**WELWYN HATFIELD BOROUGH COUNCIL
EXECUTIVE DIRECTOR - PLANNING, PUBLIC PROTECTION AND GOVERNANCE**

Application No: 6/2021/1829/HOUSE
Location: 18 Worcester Road Hatfield AL10 0DX
Proposal: Demolition of rear conservatory and erection of single storey rear extension and front lean to porch.
Officer: Ms Kirsty Shirley

Recommendation: Granted

drawing title: PROPOSED FRONT ELEVATION

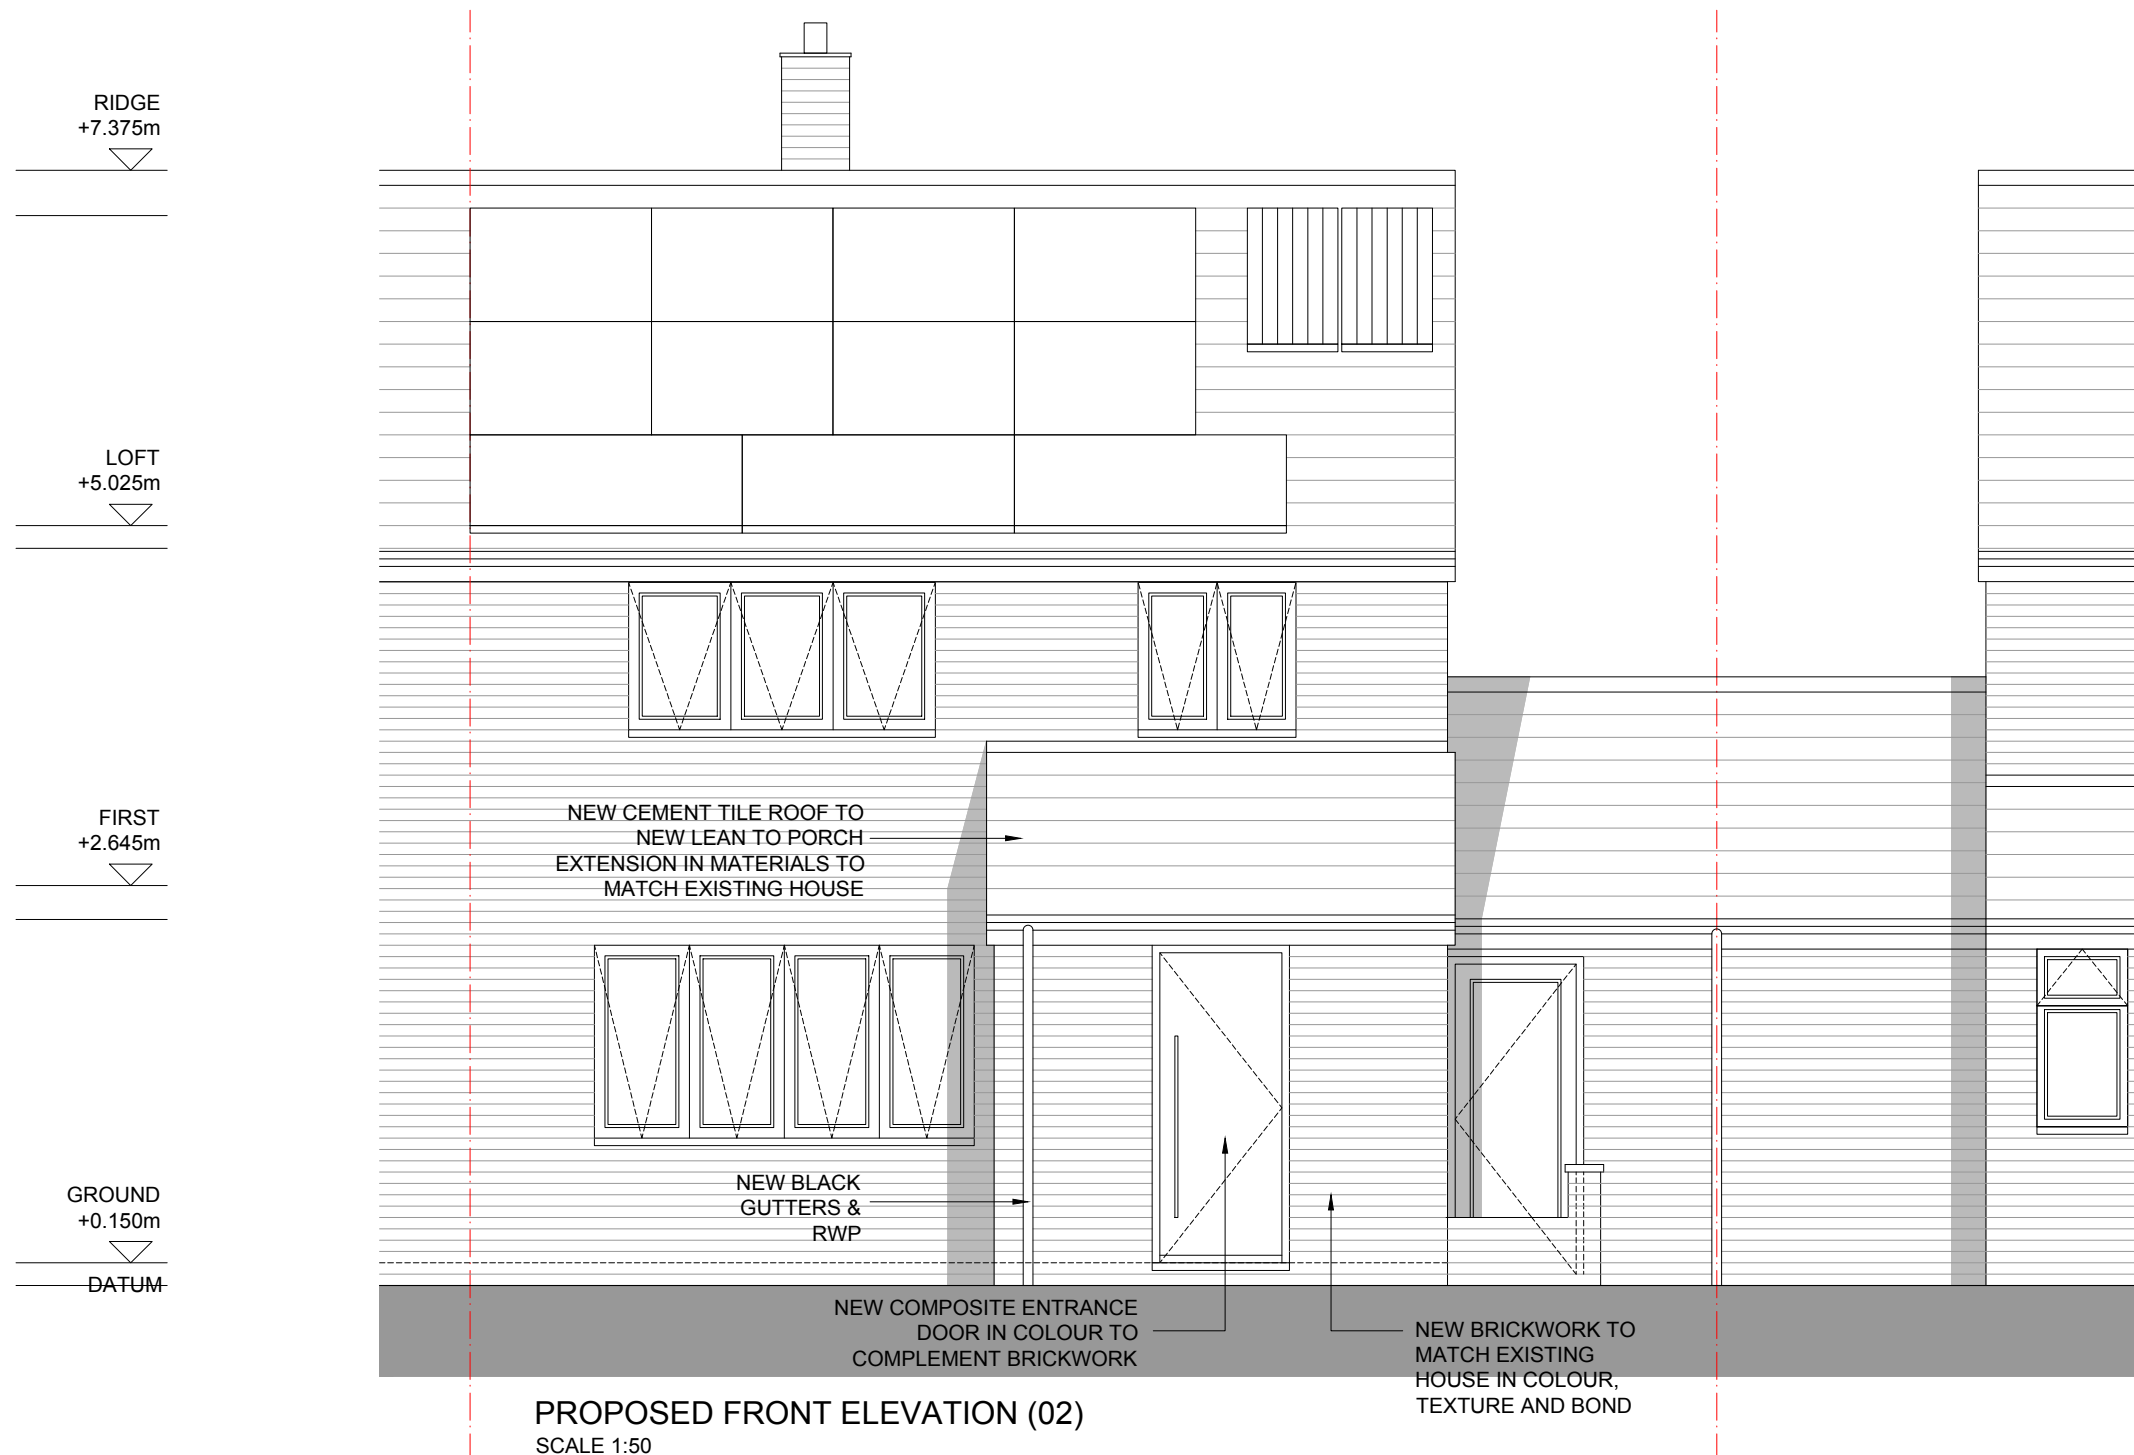
<p>Would the development reflect the character of the area?</p> <p><input checked="" type="checkbox"/> Yes <input type="checkbox"/> No</p> <p>Comment (if applicable): The front porch extension would be subordinate to the existing dwelling and the pitched roof would be in keeping with the application dwelling and wider area. The proposed rear extension would extend across the width of the dwelling and would be limited depth and height, appearing subservient to the application dwelling. The rear extension would be concealed behind the application dwelling but matching materials can be secured by condition to ensure the front and rear extensions would remain in keeping with the application dwelling and wider area.</p>
<p>Would the development reflect the character of the dwelling?</p> <p><input checked="" type="checkbox"/> Yes <input type="checkbox"/> No <input type="checkbox"/> N/A</p> <p>Comment (if applicable): See above</p>
